Planning Officer: Mr S Davis

Planning Application Ref: Y/57/21/PL

Location: Sunnymead, North End Road, Yapton, BN18 0DL

Description of works: Demolition of existing dwelling and outbuildings and erection of 5 dwellings comprising 2no 4 bed houses & 3no 3 bed house (resubmission following Y/33/20/PL). This site is in CIL Zone 3 & is CIL Liable as new dwellings. This application is a Departure from the Development Plan

**Tree Protection Zone - 'No Dig' Construction**

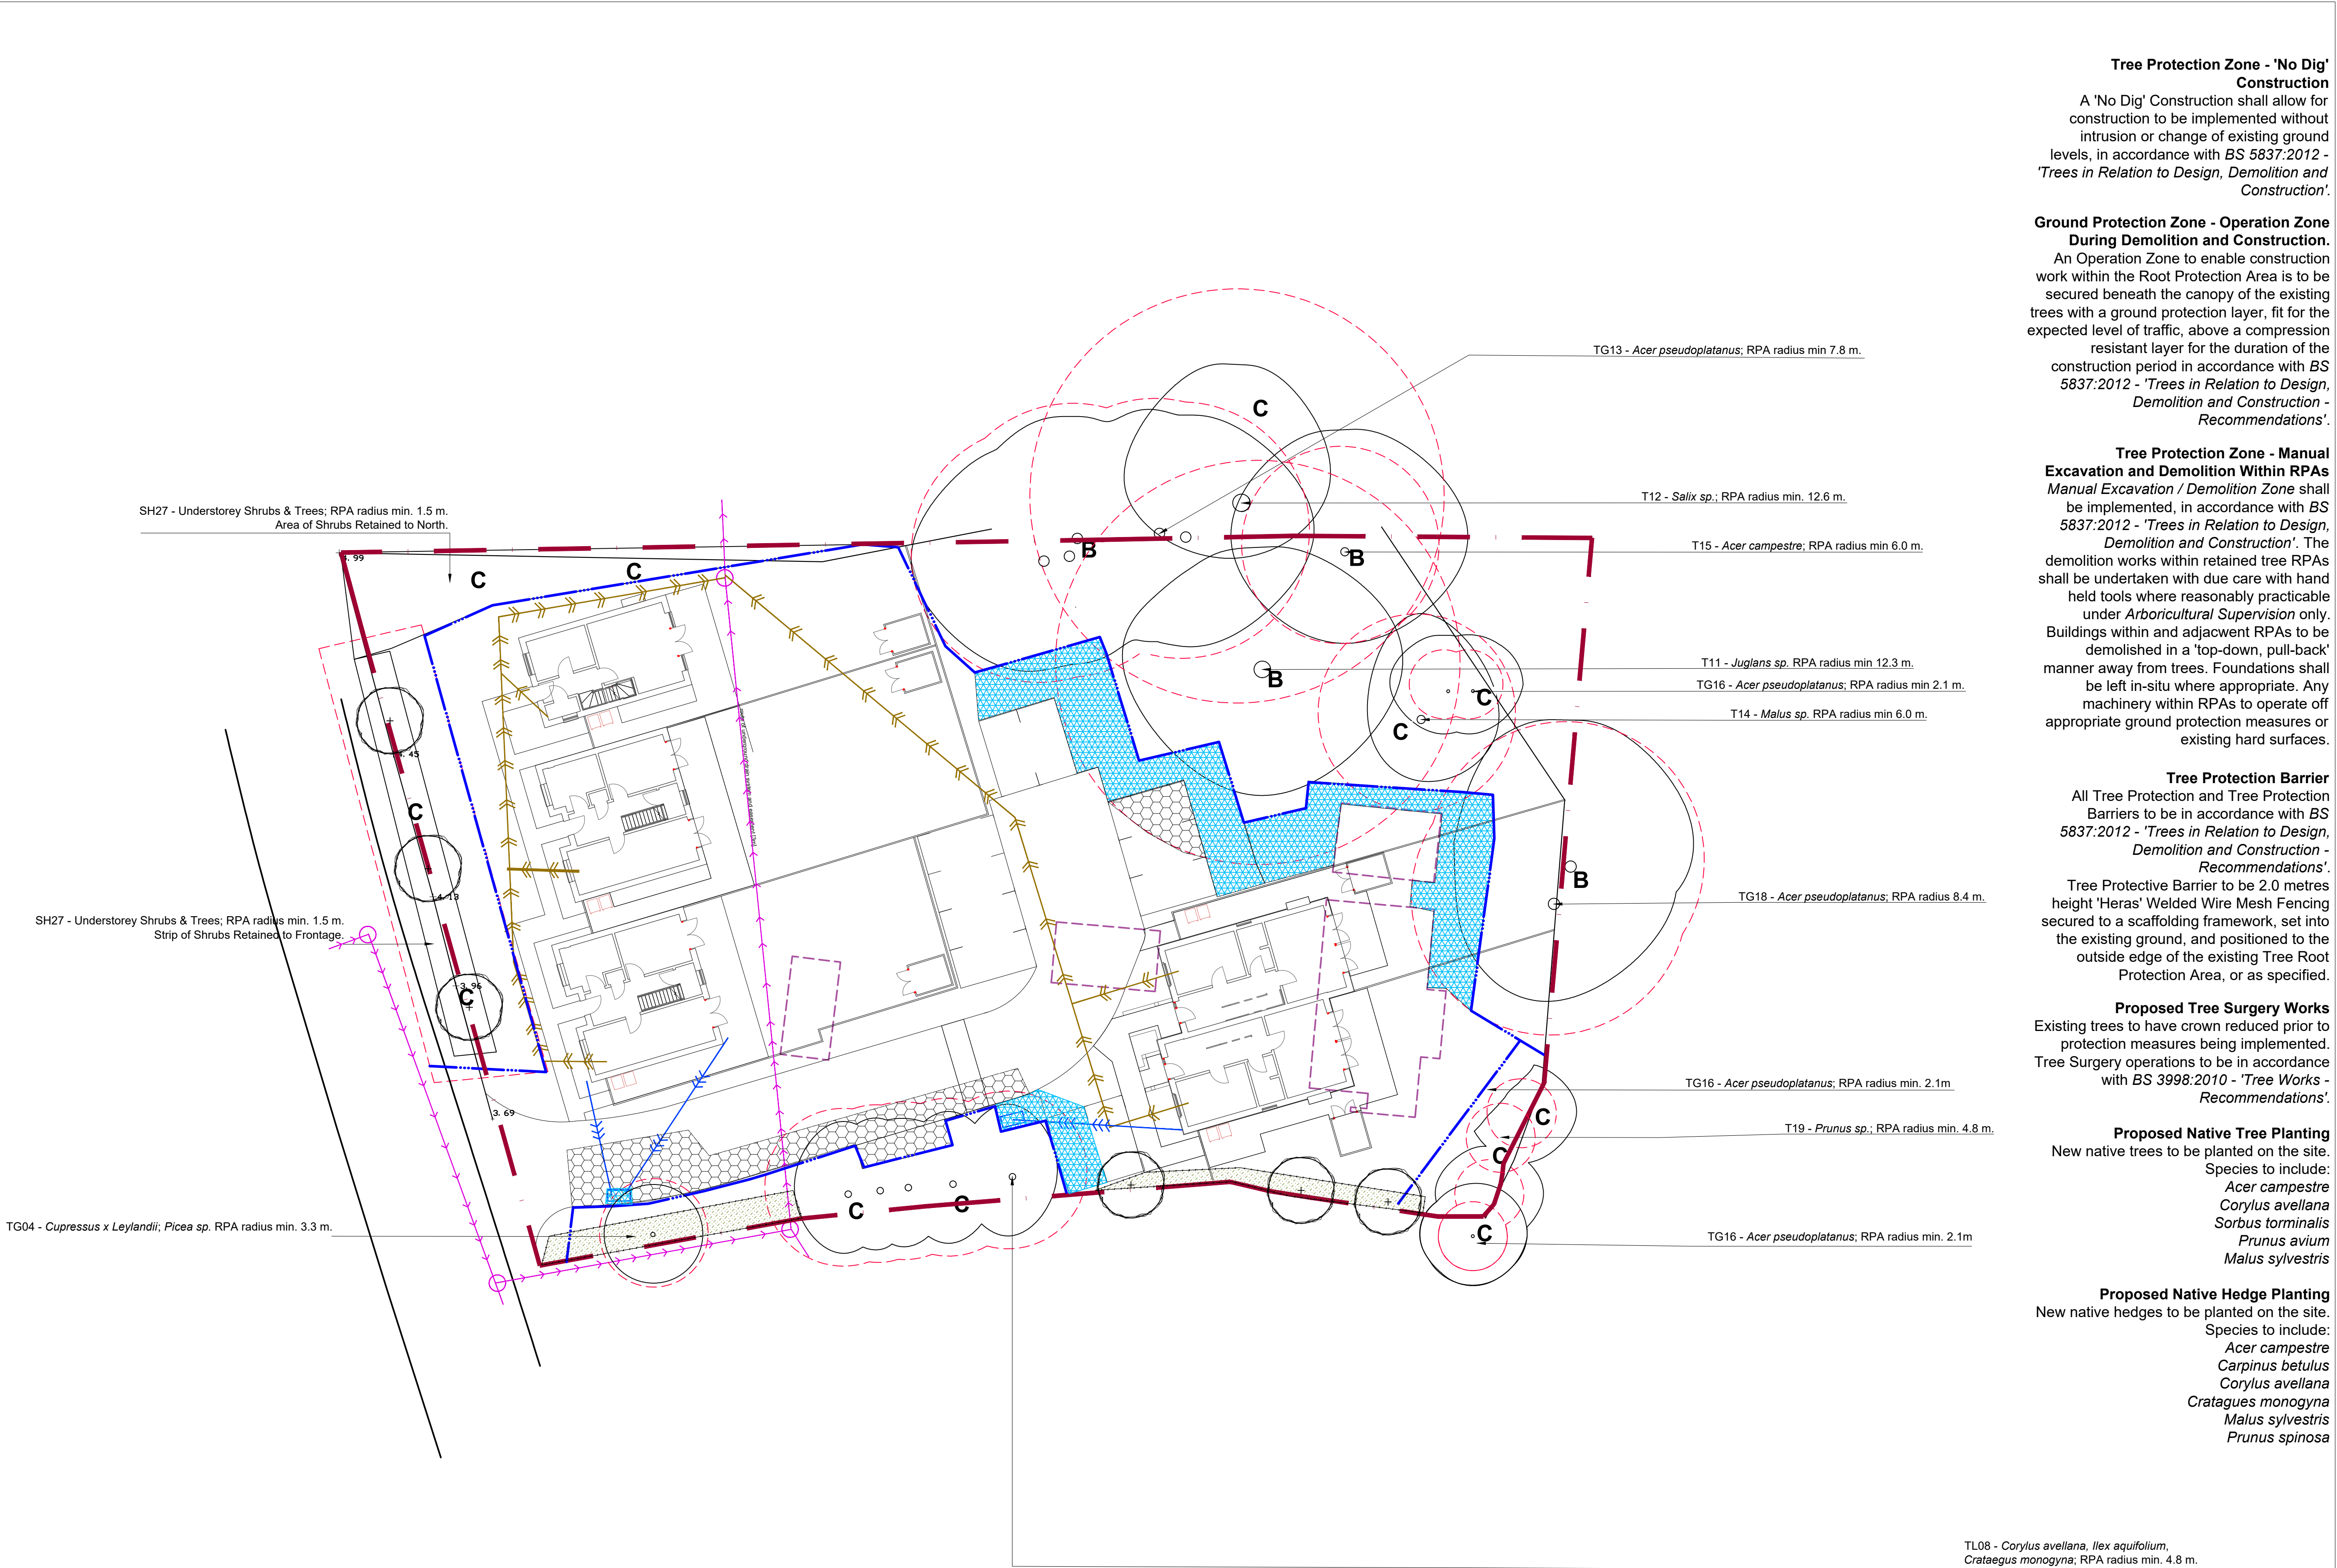
- iii) Paragraph 5.29. Early installation of 'No-dig' driveway required.
- Amend wording to read 'The No-dig construction areas within the main site access/driveway and parking area adjacent T11 must either be constructed in entirety prior to construction of the dwellings, such that this can then be used as construction access (with optional renewal of the final wearing layer added once construction of the dwellings is complete) or a sacrificial cellweb layer over additional geo-textile filter membrane employed throughout the construction phase.
